MEADOW RANCH II & III

GRADING & EROSION CONTROL PLAN COVER SHEET

C1.12 PROJECT 61209
MVE DRAWING GEC-ED

C1.2
SHEET **2** OF 12

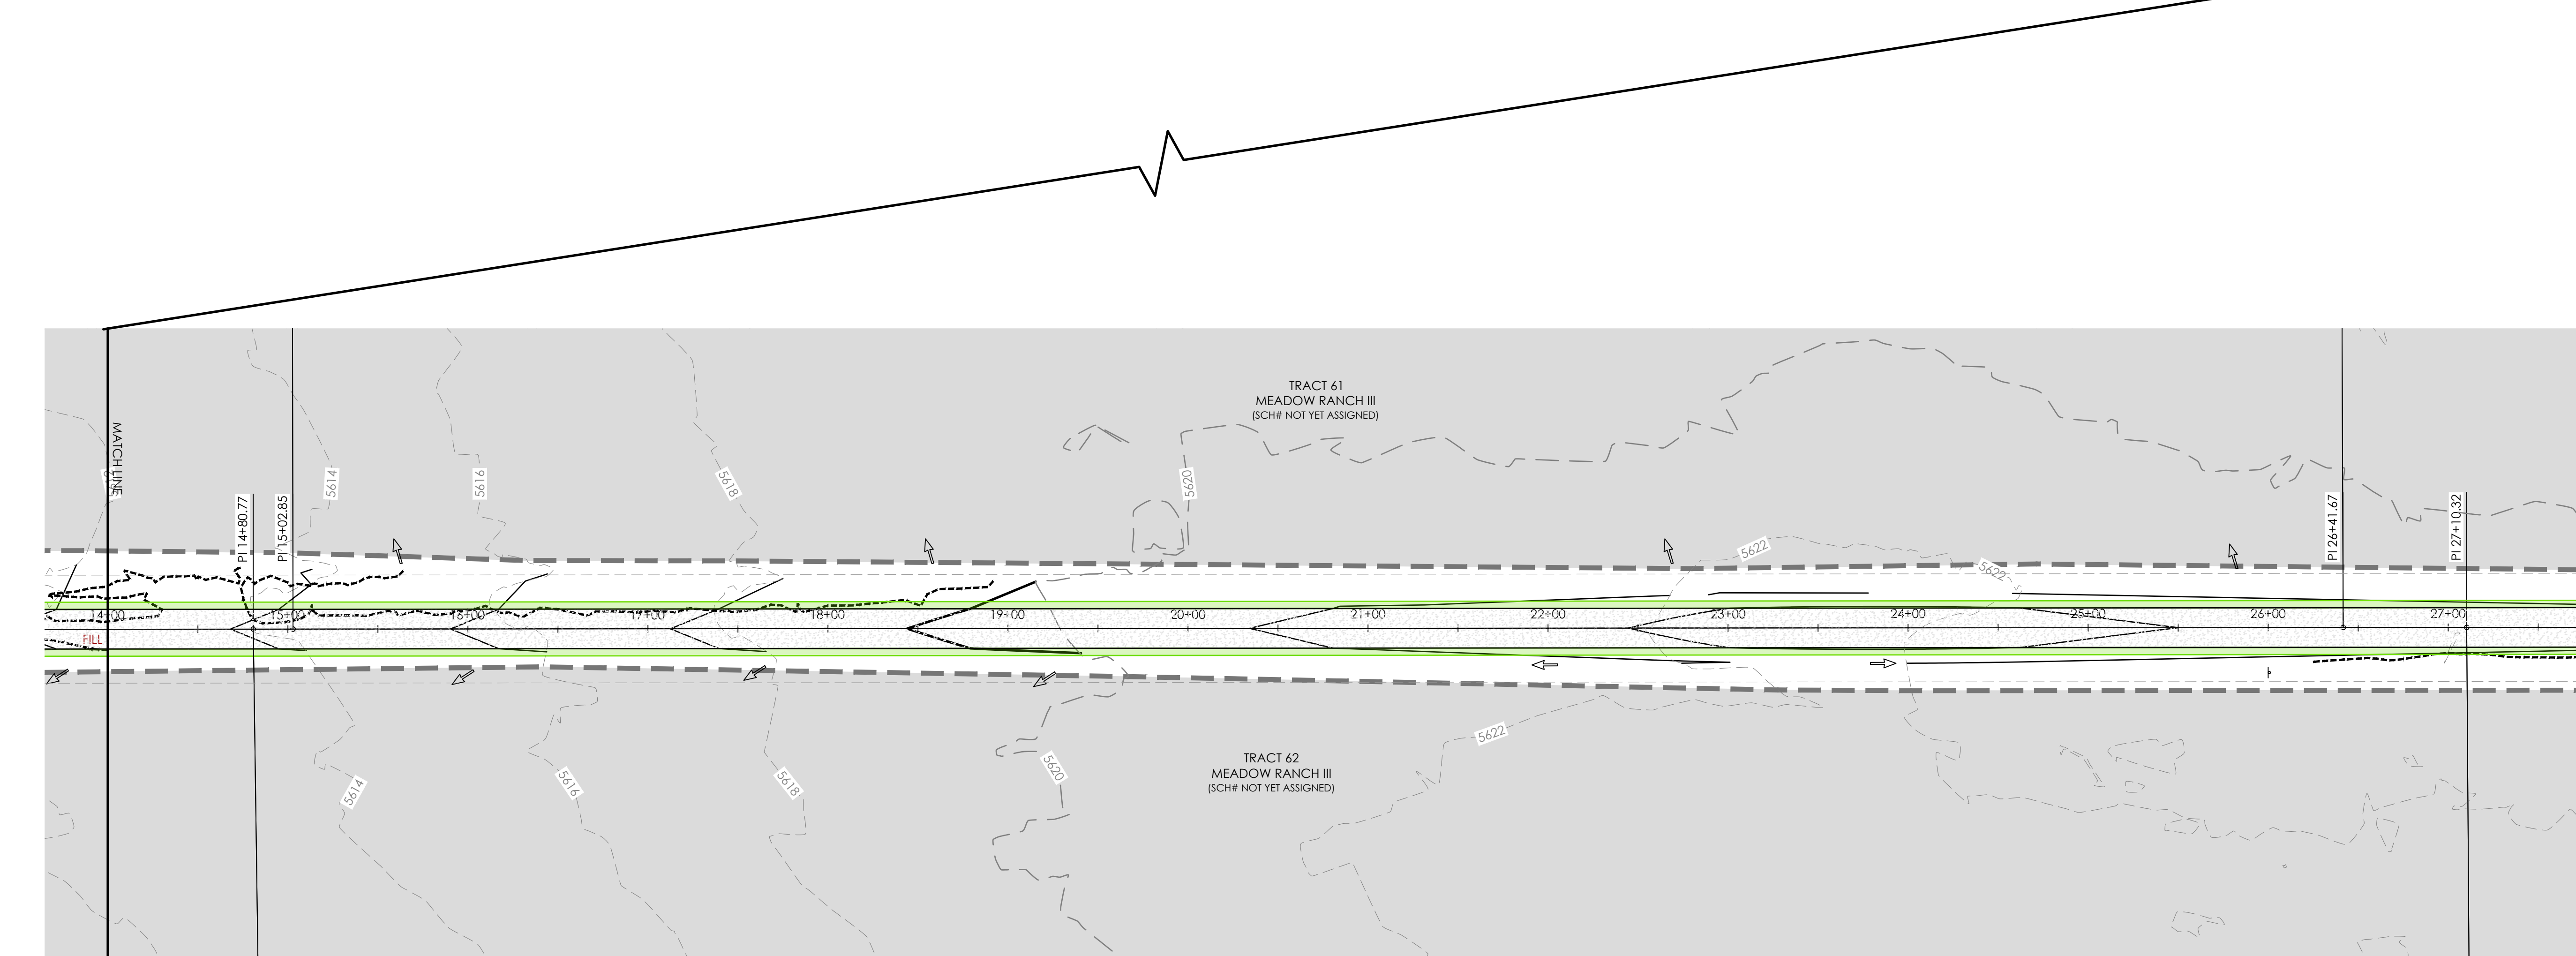
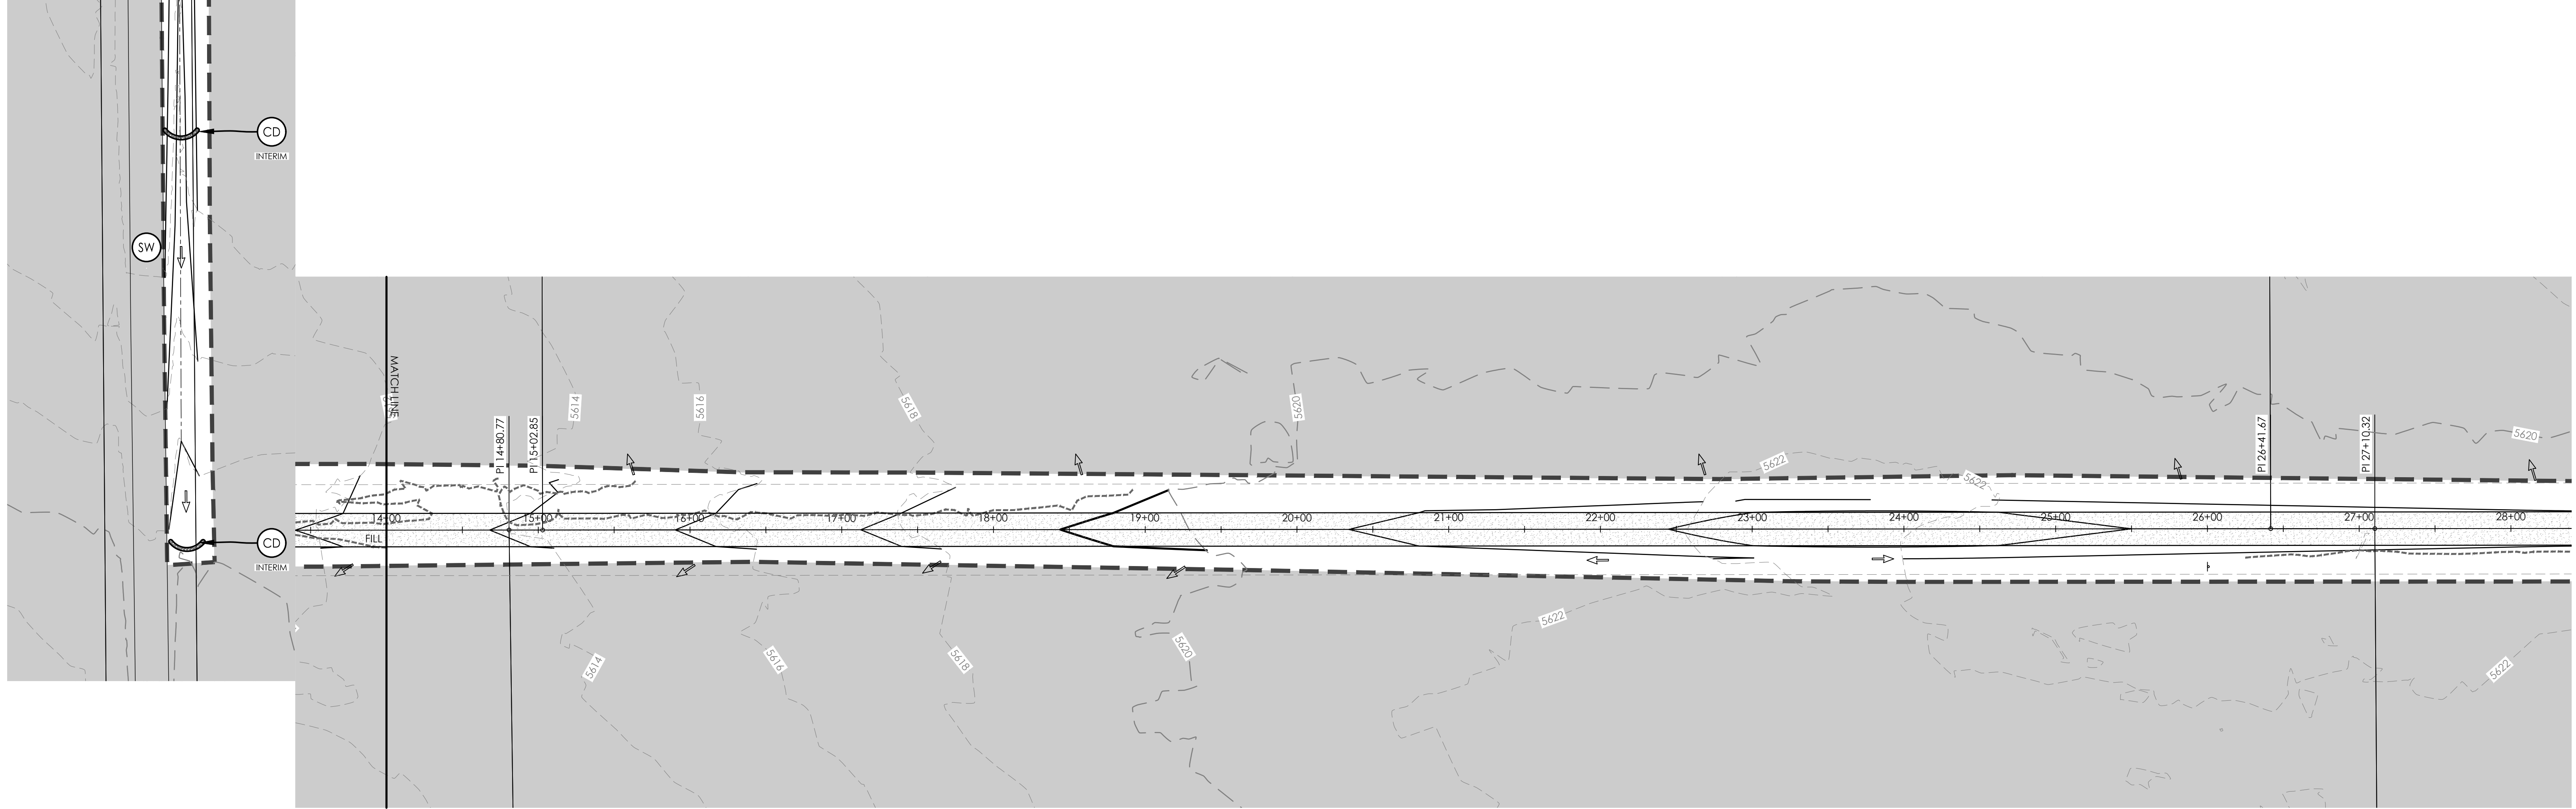
GEC Plans call for Straw Bale Barriers - provide or remove from SWMP.

All RPAs must be delineated and identified because they are permanent control measures treating the site. It must be identified that for the RPA areas, vegetation should have a uniform density of at least 80%. Topsoil suitability shall be demonstrated and steps for proper preparation of topsoil per recommendations in MHFD Detail T-0 Table RR-3 shall be incorporated into design. Provide detail for RPAs and UIA/RPA interface. See additional comments on the Drainage Report.

Provide detail for ditch. Will the concentrated ditch flow create erosion downstream? What are velocities?

Shouldn't there be more grading of the ditch to the culvert? It seems like this slope may be very shallow.

Provide detail/dimensions for proposed ditch.

identify radius of cul-de-sac bulbs, typical

C1.3

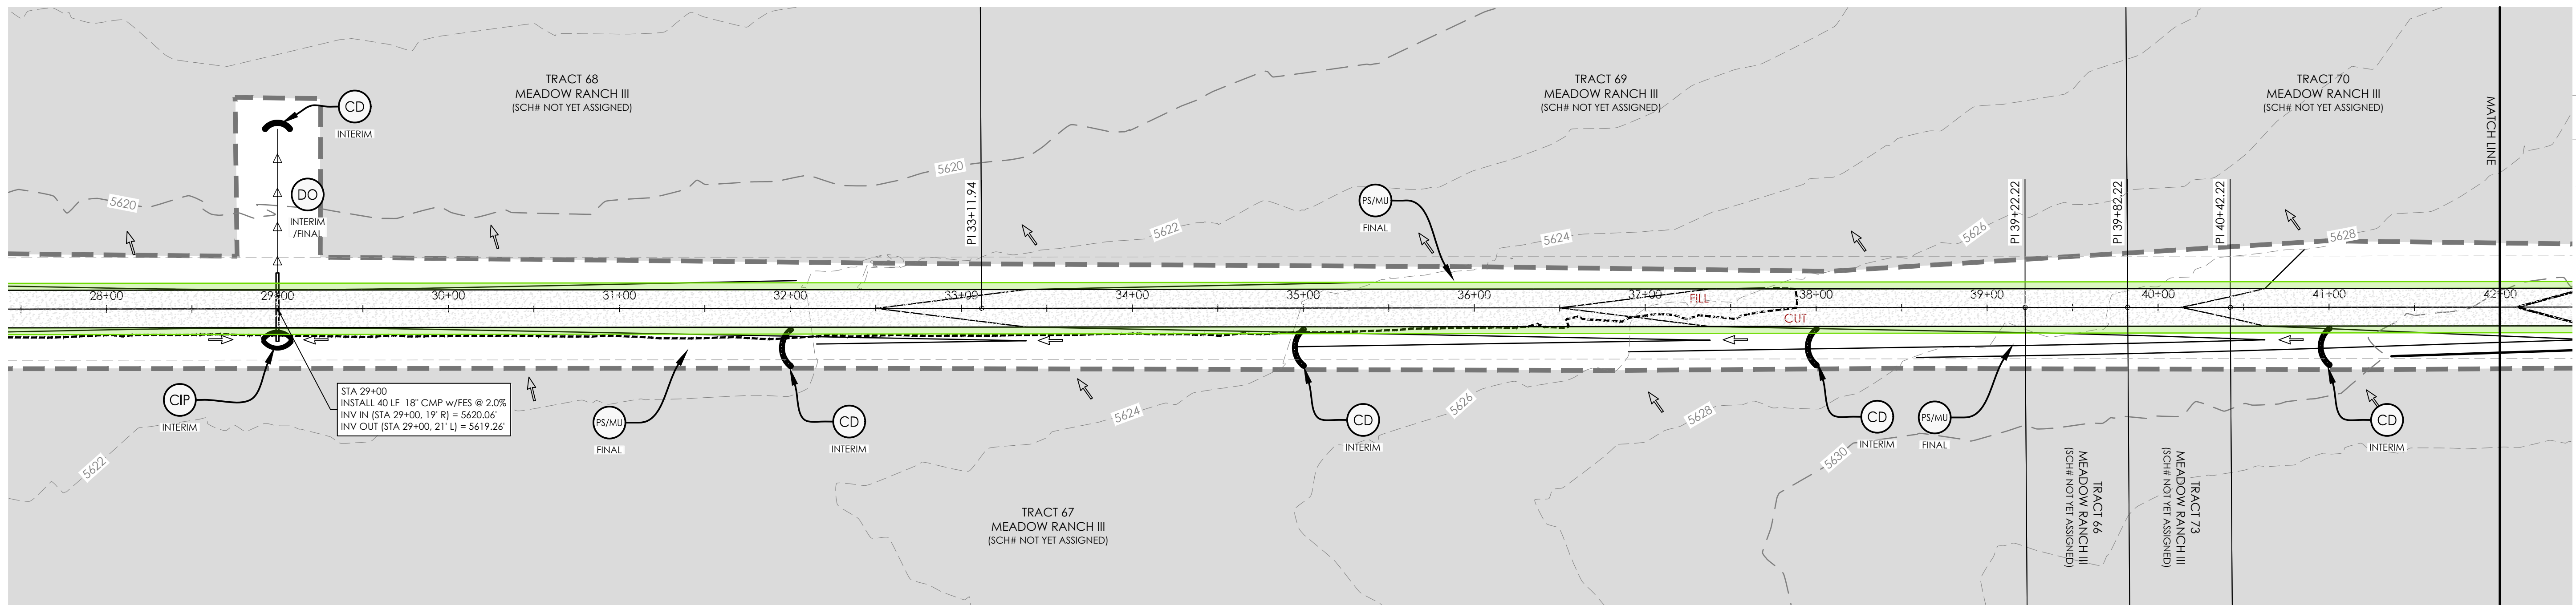
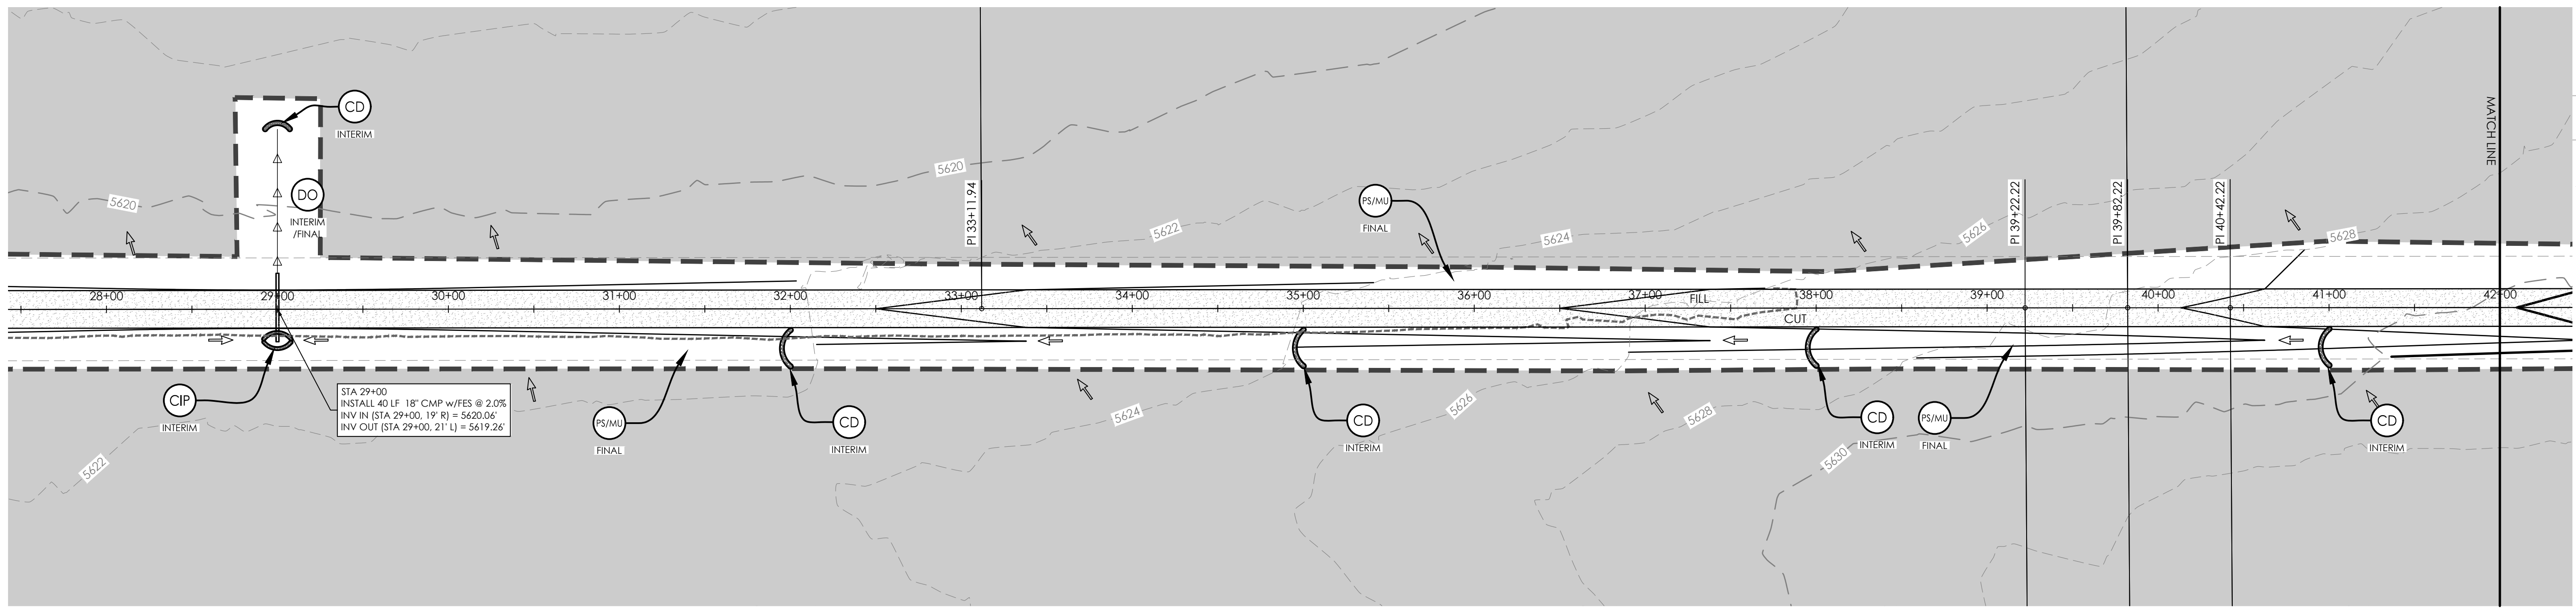
Provide detail for ditch. Will the concentrated ditch flow create erosion downstream? What are velocities?
label and provided details on Meyers Road ROW

identify centerline radius, typical

C1.7
SHEET 7 OF 12

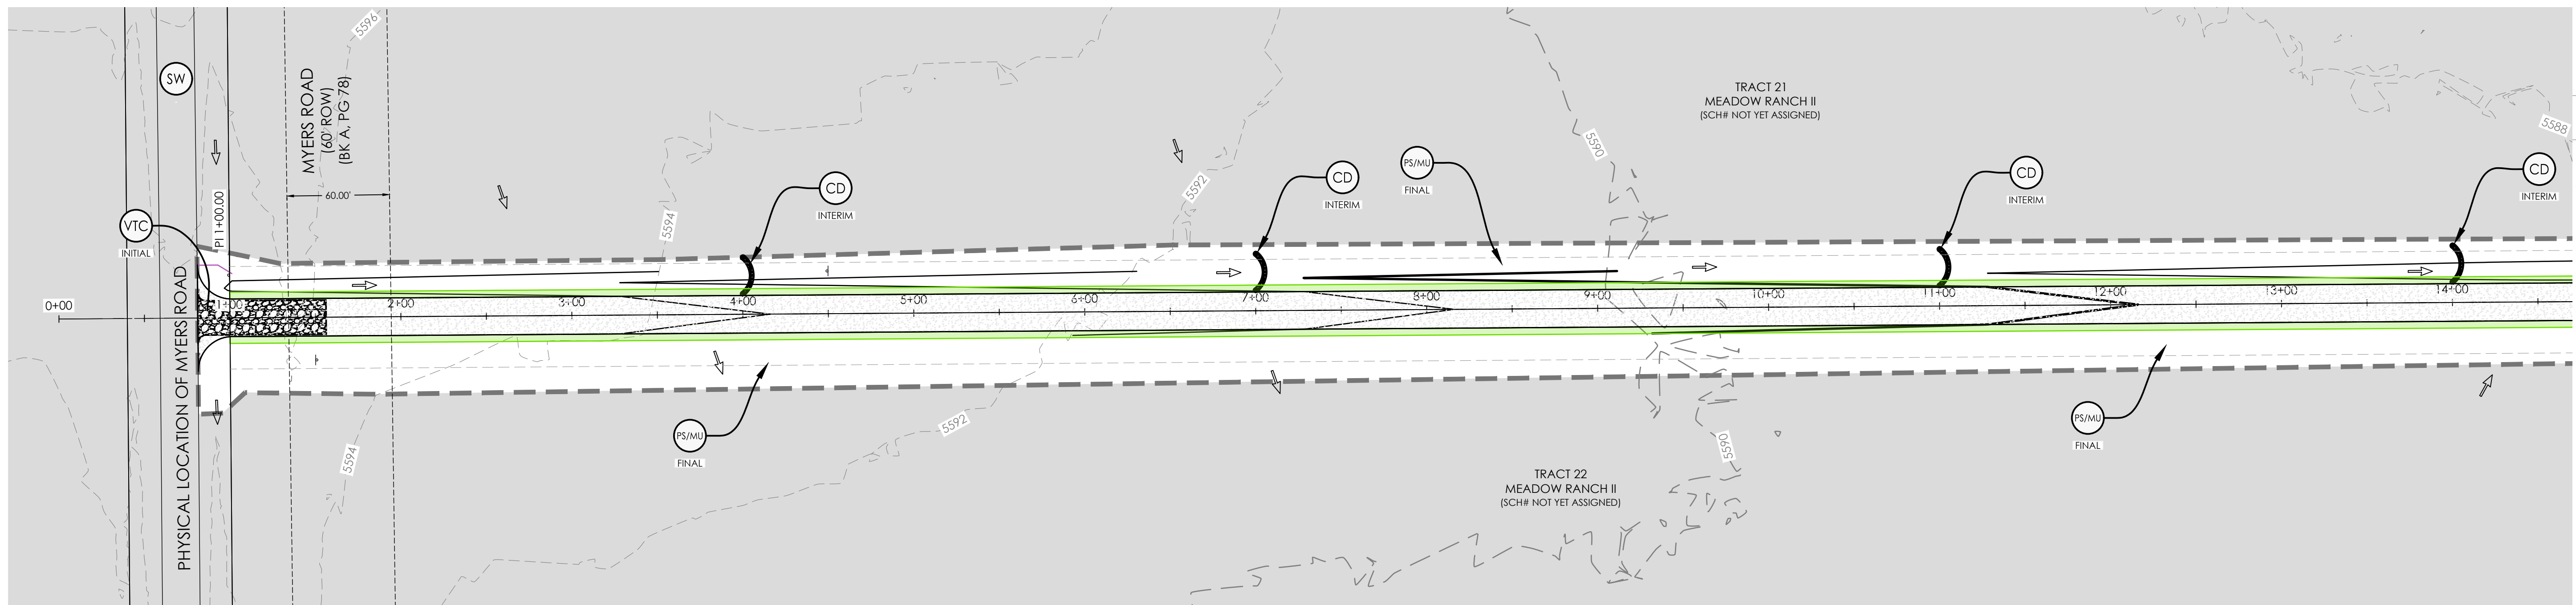
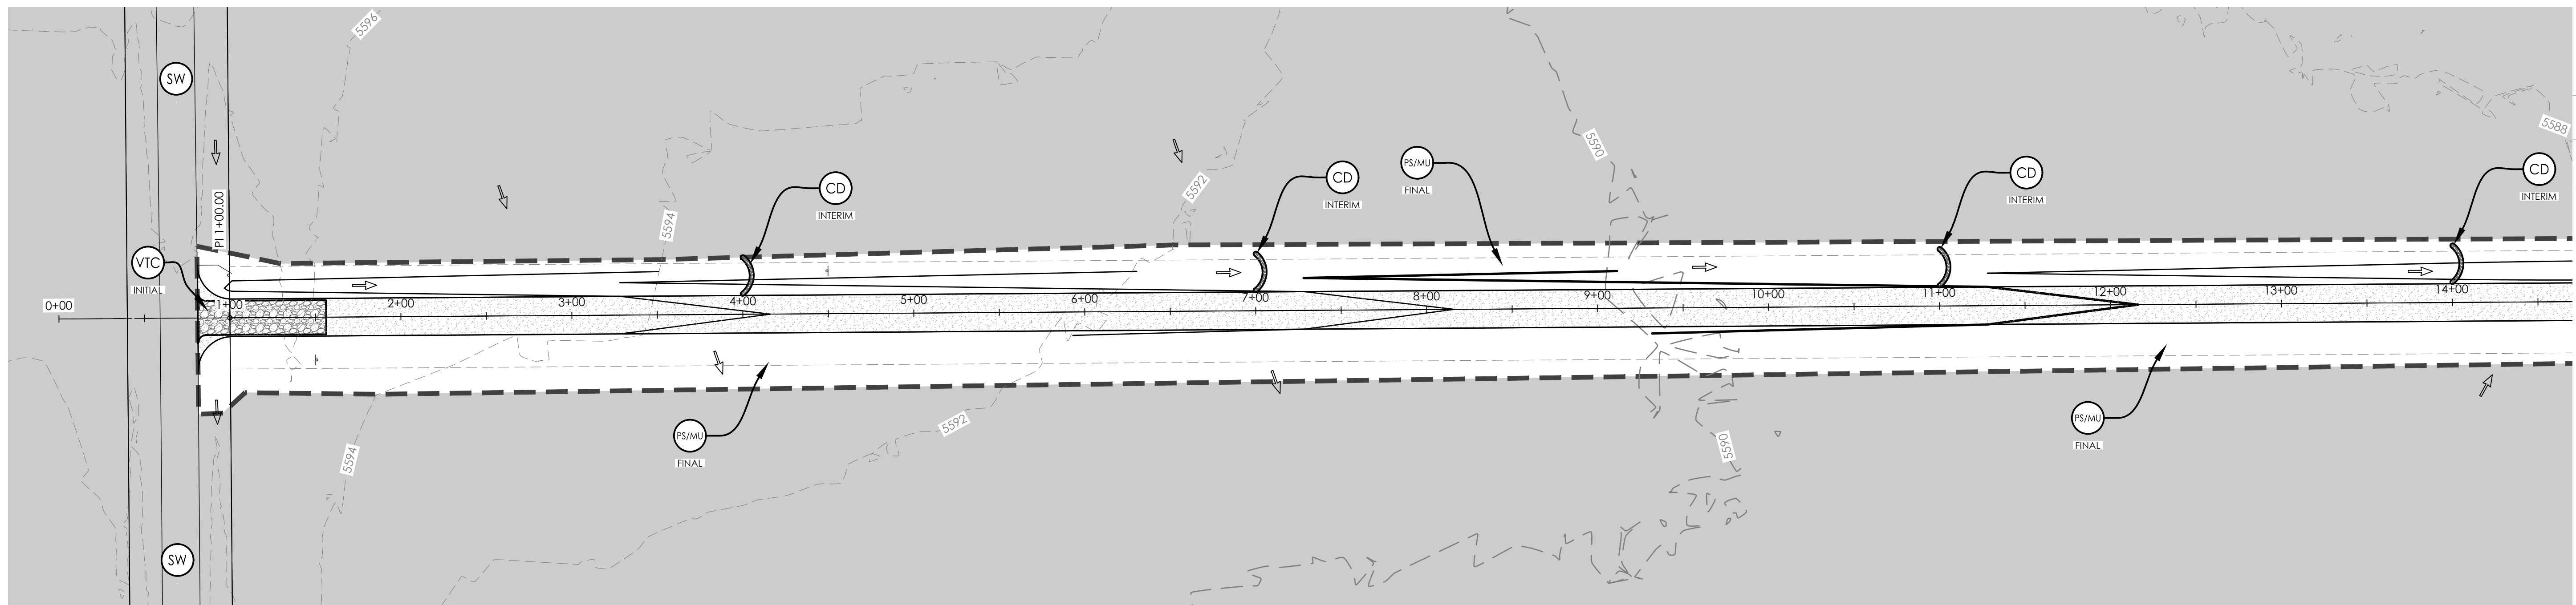
Provide details on
Meyers Rd ROW

Provide detail for ditch. Will the concentrated ditch flow create erosion downstream? What are velocities? Typical Comment.
